Application for a non-material amendment following a grant of planning permission.

Non-material amendment following the grant of FP/206/17/HHA to re-introduce a proportion of original glazing arrangement, remove central vertical pillar between two garage doors, introduce a slot window into the ~~the~~ former left sheet.

Unit:		House number:	1	House suffix:	
House name:	BEACH LODGE				
Address 1:	STRAND WAY				
Address 2:	FELPHAM				
Address 3:					
Town:	BOGNOR REGIS				
County:	WEST SUSSEX				
Postcode (optional):	PO22 7LH				
Description of location or a grid reference. (must be completed if postcode is not known):					
Easting:		Northings:			
Description:

Replacement 13 No. windows, 3 No. new windows, re-cladding of all external wall surfaces, reinstatement of balcony & single storey rear extension.

Drawing No.  
PL104.C

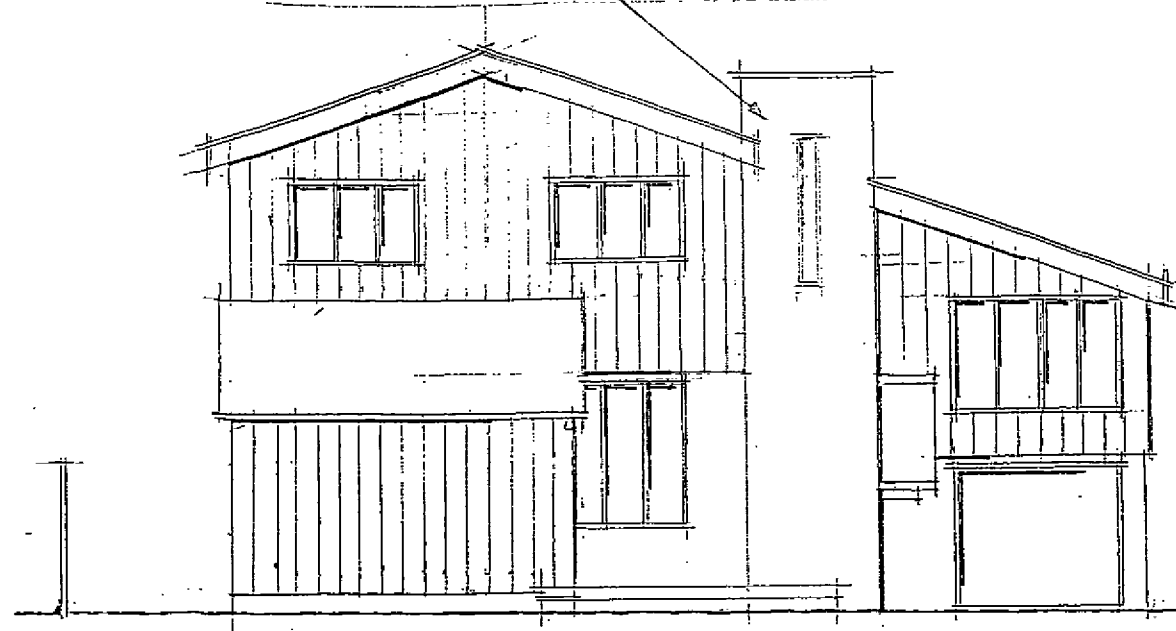
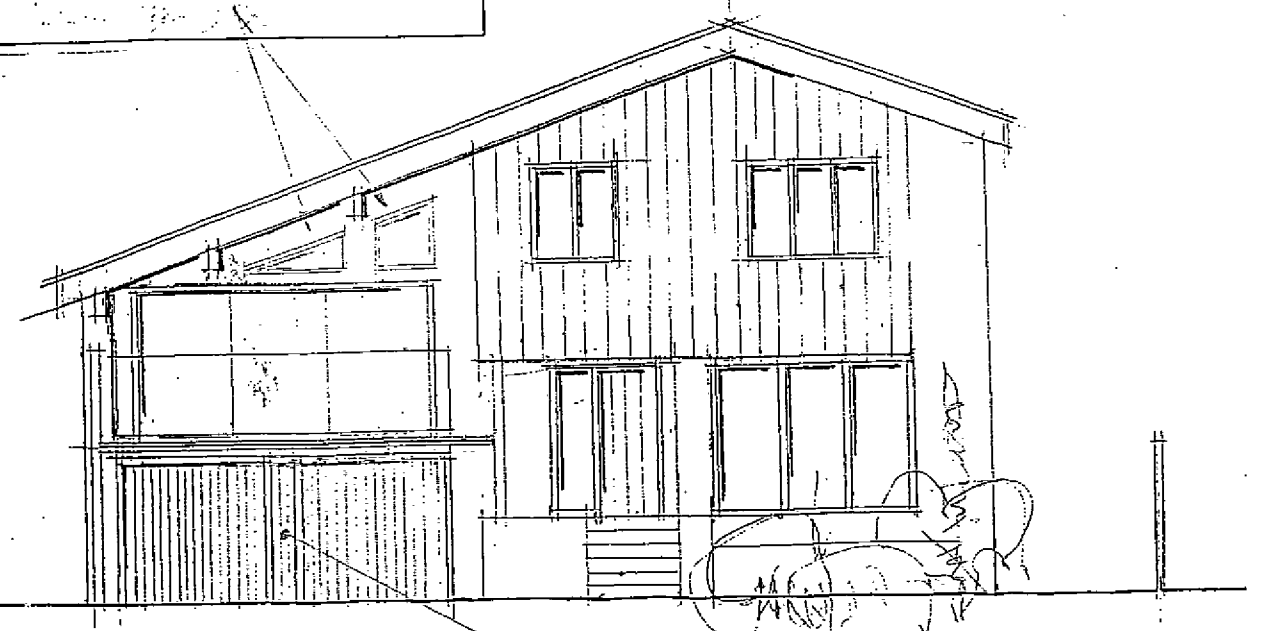
Re-introduce a proportion of the original glazing arrangement (Ref. Drawing PL102 Elevations as Existing) to allow direct light into the upper part of the vaulted ceiling in the Drawing Room

Remove the central vertical pillar between the two garage doors in order to form a single opening more conducive to modern-day car width(s)

Introduce a slot window into the former lift shaft to allow light into the storage room and to improve the visual appearance
